# **William H. Clark, Jr, PE Consulting Engineer**

Re: Changes to Permitted Plans  
Celtic Crawlers Off-Road Garage  
214 Fish Drive  
Angier, NC 27504

Per the request of the inspection authority, I provide this letter expressing my agreement with the following changes:

FLOOR PLAN -
PLUMBING

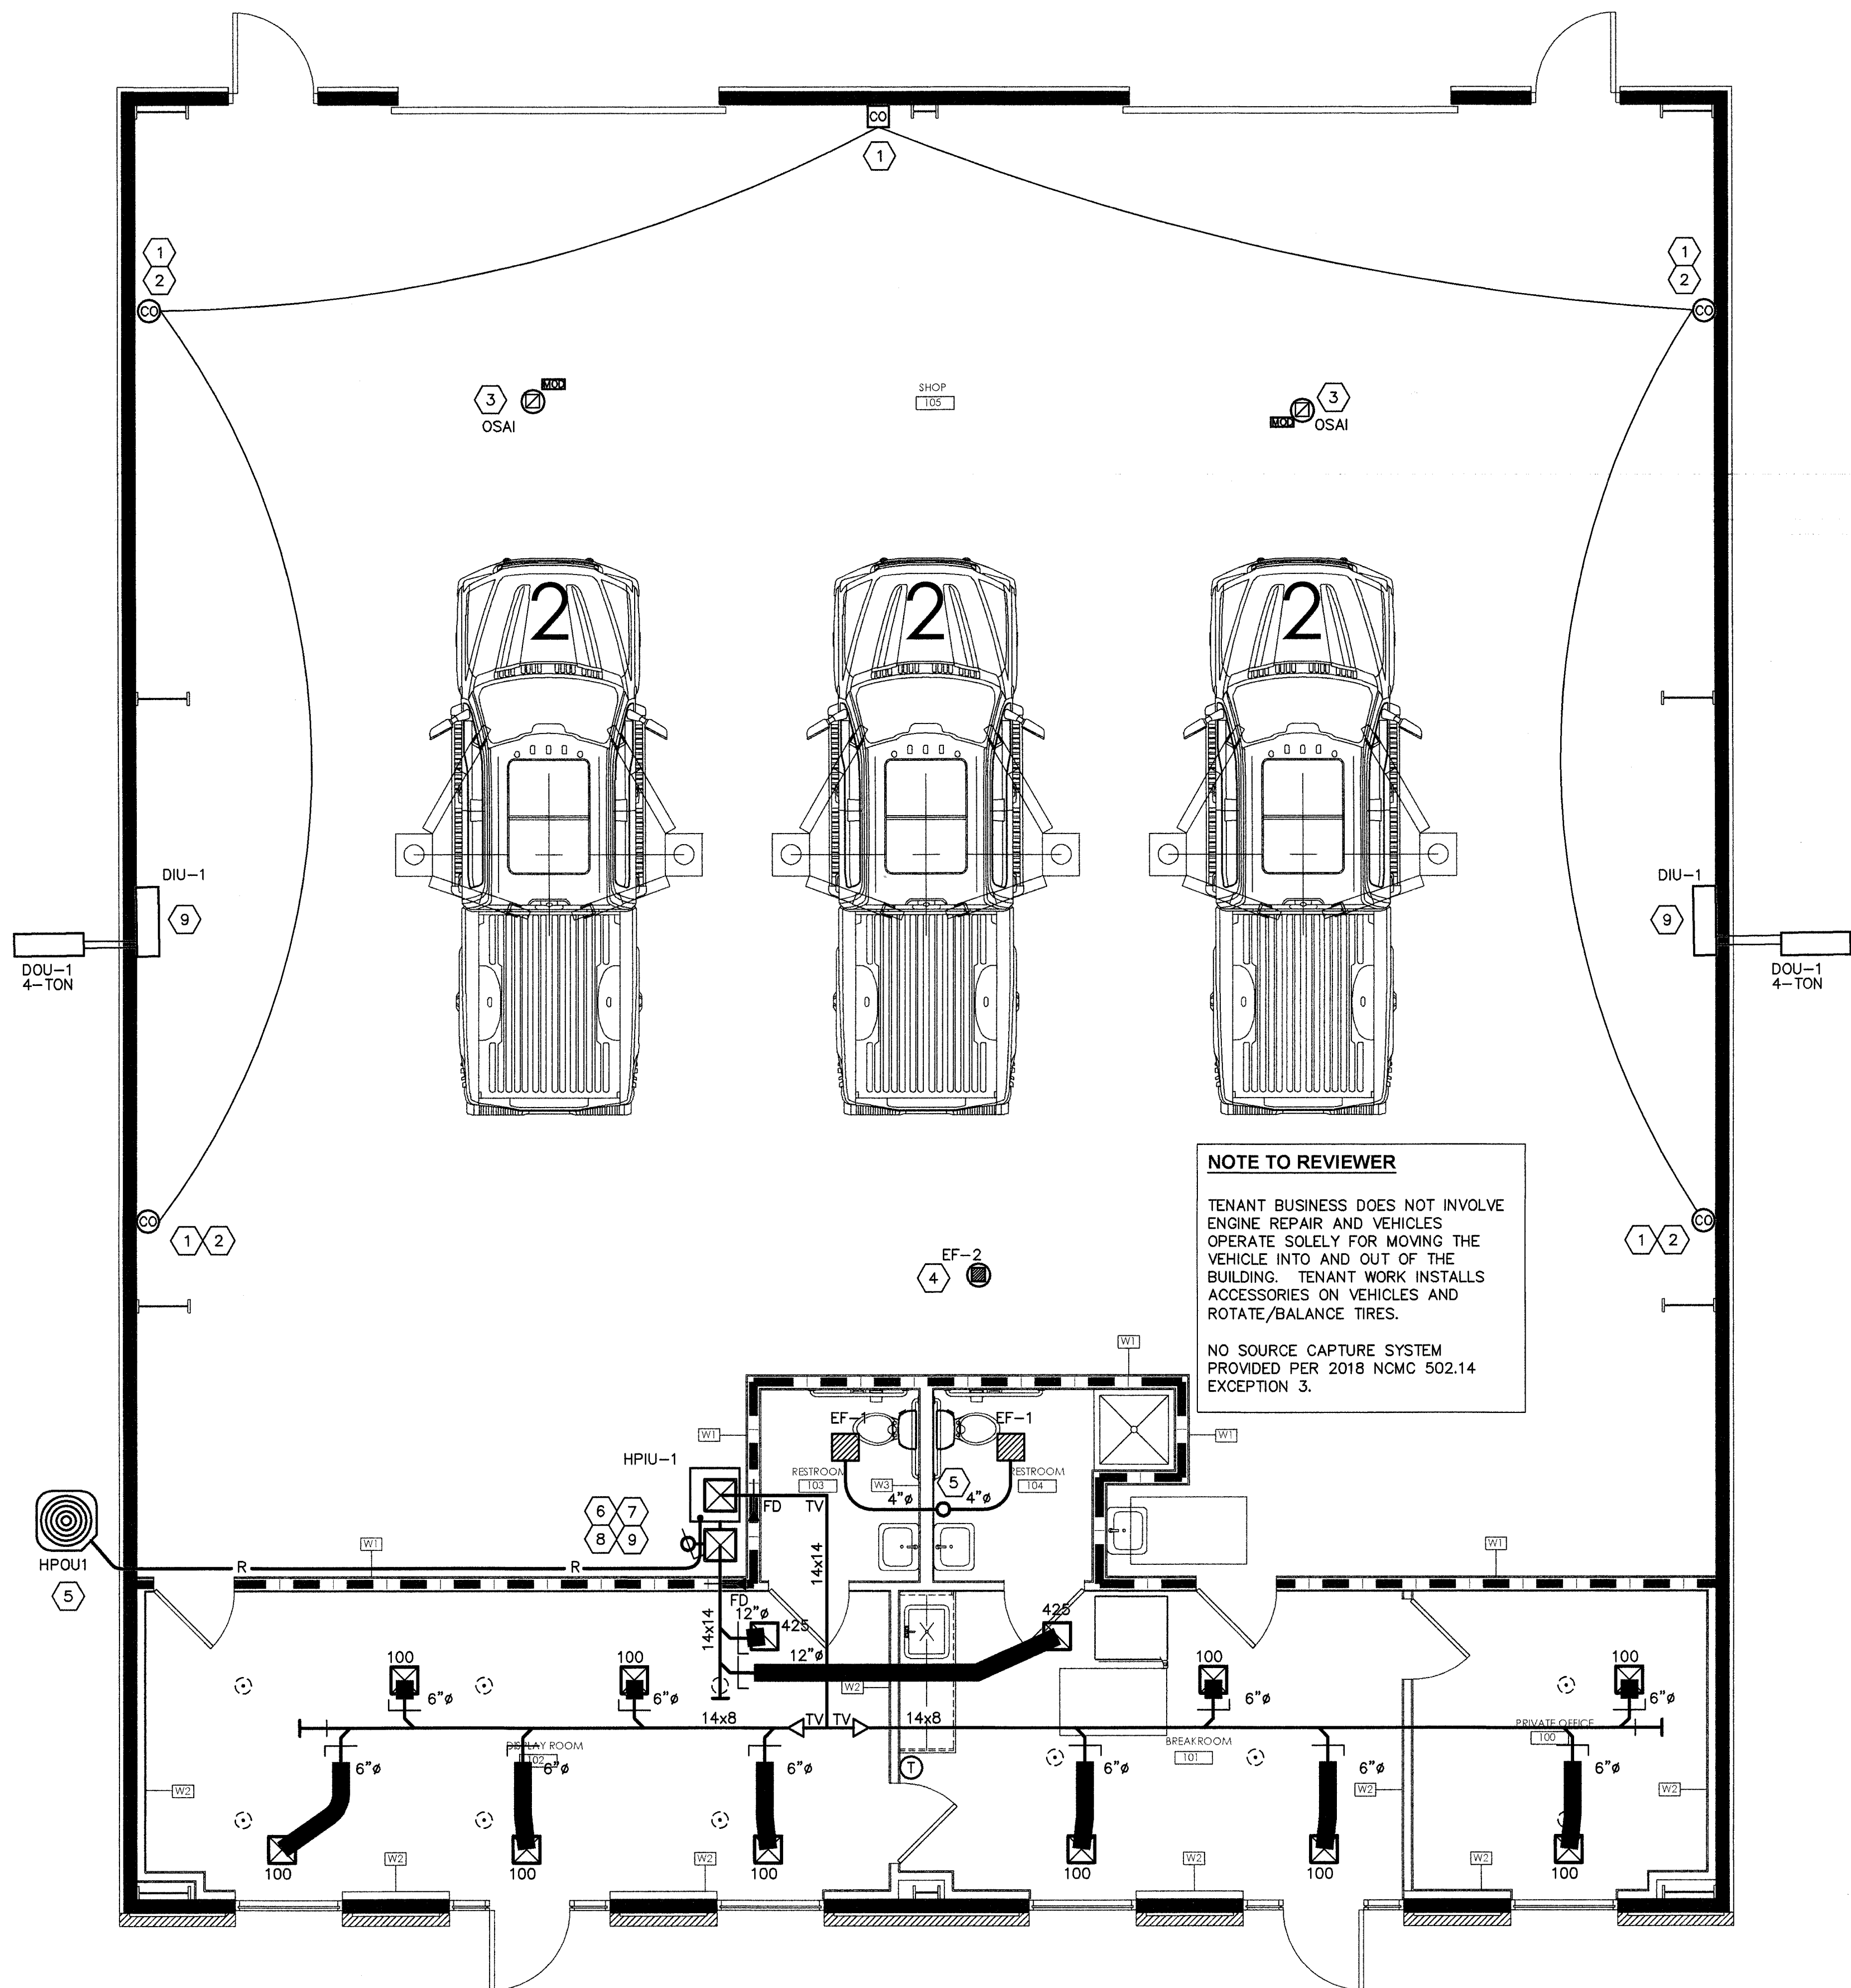
- 1) Please reuse the (2) combination exit sign/egress light fixtures at the entry doors. That would replace (2) new exit signs and (2) new egress lights I showed.
- 2) I accept deleting the floor outlet and providing a wall receptacle behind the workstation.
- 3) I accept the new exterior wall locations for the exhaust fan and outside air louvers rather than on the roof.
- 4) I accept the new locations for the HVAC equipment and the routing of all drainage out to the Plan East side of the drawing. Please use a fire-rated access panel/door.
- 5) I accept the American Standard equipment as a substitution for the specified Goodman equipment.
- 6) I accept reducing the quantity of diffusers and the increased duct sizes on the remaining ones.
